Please see responses to your questions below:

2. Please provide a Block Plan at a scale of 1:500 or 1:200 to showing

Drawing # 3

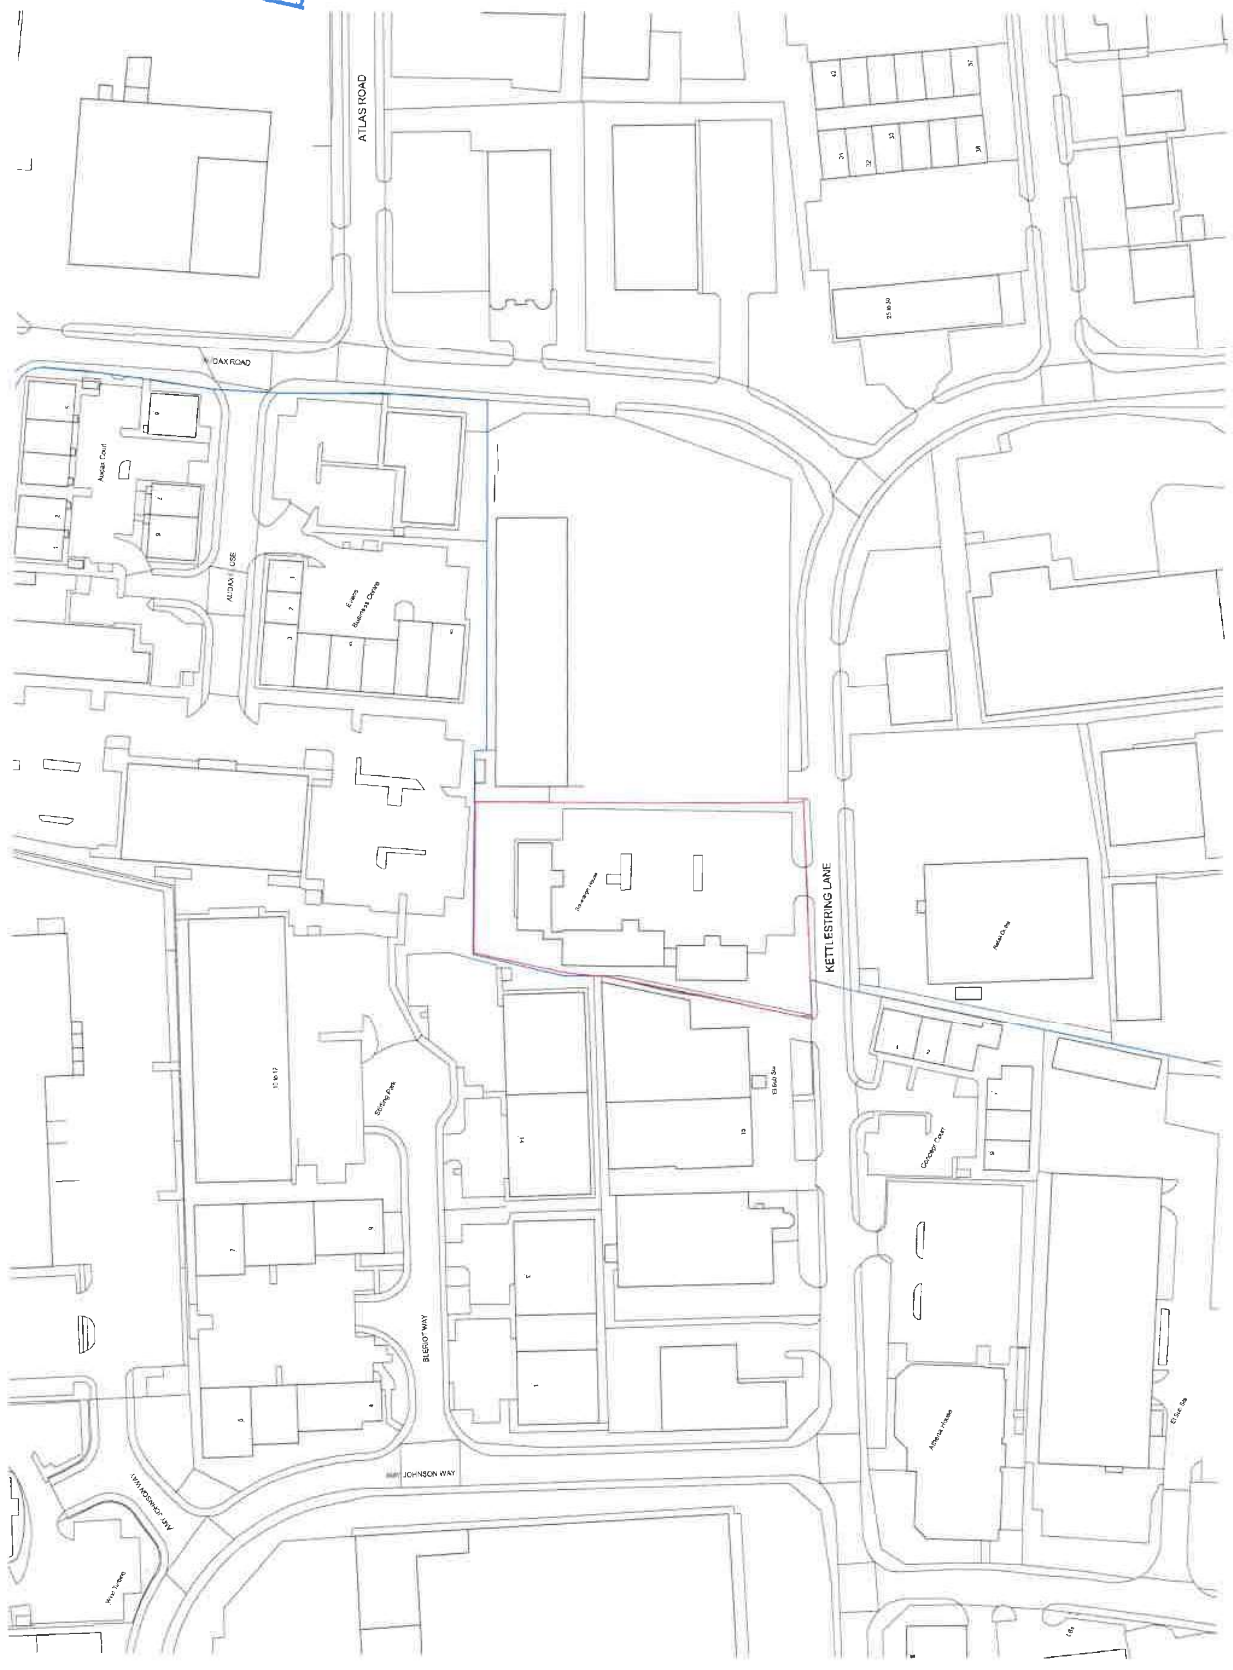
3. An accurate location plan with the site boundaries edged in red are required (scale 1:1250 or 1:2500).

Drawing # 3 shows the boundary marked in red.

Front Elevation (south)

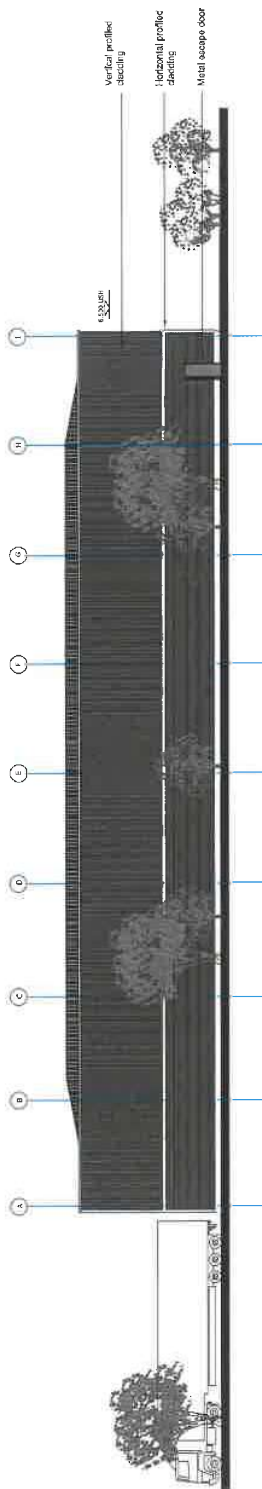
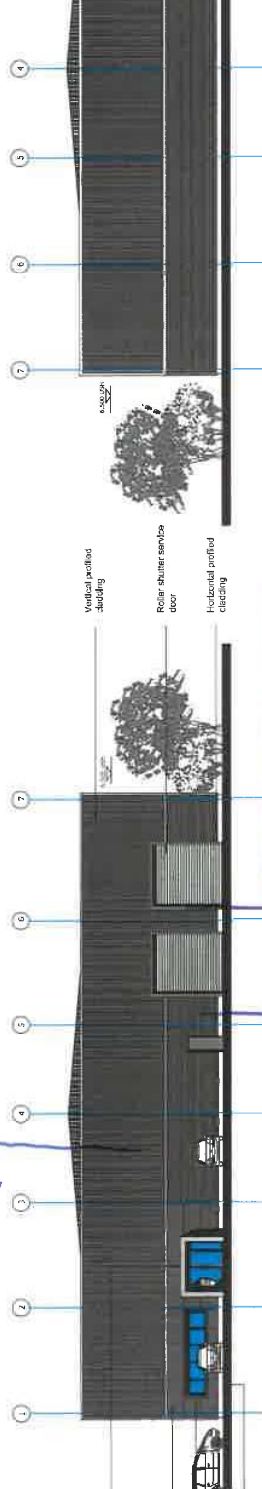
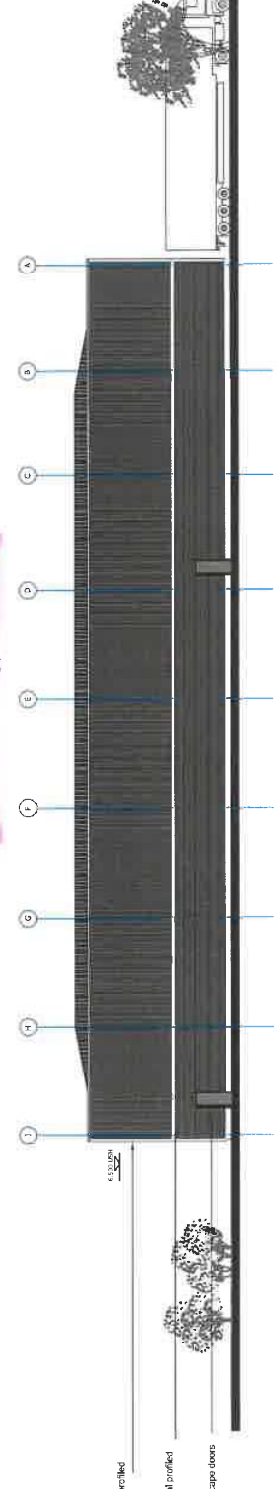
5. Existing and Proposed elevations at a scale of 1:50 or 1:100.

5. The submitted drawings appear to show two different styles/designs please can you confirm if this is correct in terms of the details?

Drawing # 4

There are two styles of signage for the building. The main one which is 4800mm in length.

The two smaller ones indicate the Delivery / Collection doors for the site, The font and colour is the same.

Drawing #1

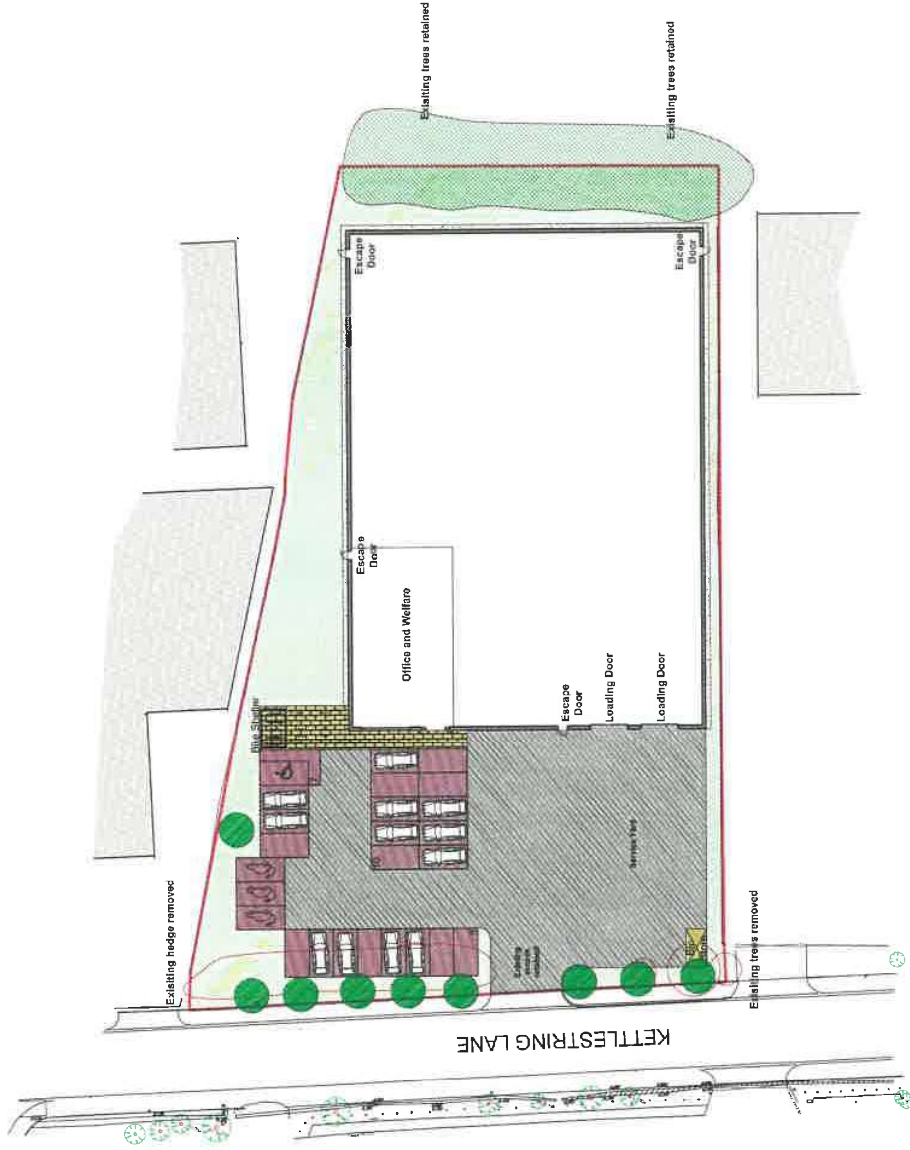
1. The direction of north

4. Details of parking areas including surfacing and proposed materials

Drawing # 1

Shown on Drawing 1.

Area is tarmac
